DOC23/64680-2

24 February 2023

**Open Water Surf Facility, Sydney Olympic Park Precinct (SSD-7942-MOD-2)  
EPA Advice on Modification**

**Figure Name:** Typical Capping Details

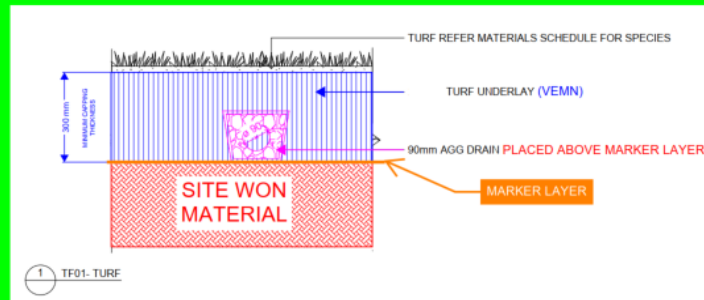
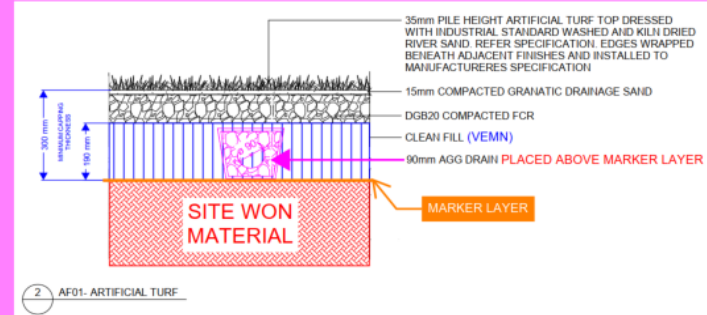
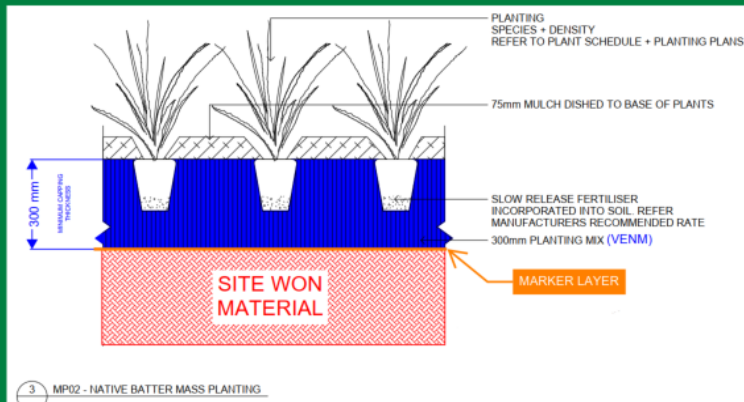
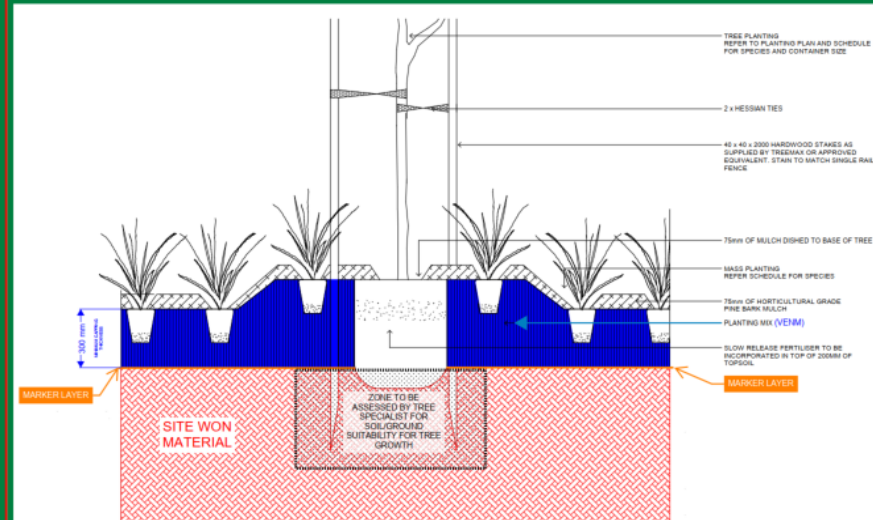
Section 5 of the Supplementary Remediation Action Plan (RAP) states the currently approved capping method of grassed areas is a geofabric marker layer underneath 300mm of compacted clay, crushed sandstone or other suitable capping covered with 200mm of topsoil. The current

modification proposes altering the capping layer to a geofabric marker layer underneath 300mm of Virgin Excavated Natural Material (VENM) certified turf underlay materials covered with natural turf.

The EPA notes the reduced capping thickness, whilst may be still functional as a barrier will likely have a reduced lifespan and will require additional ongoing management and maintenance in the long term. The additional monitoring and maintenance regimes would need to be reflected in long term environmental management plan intended for the site.
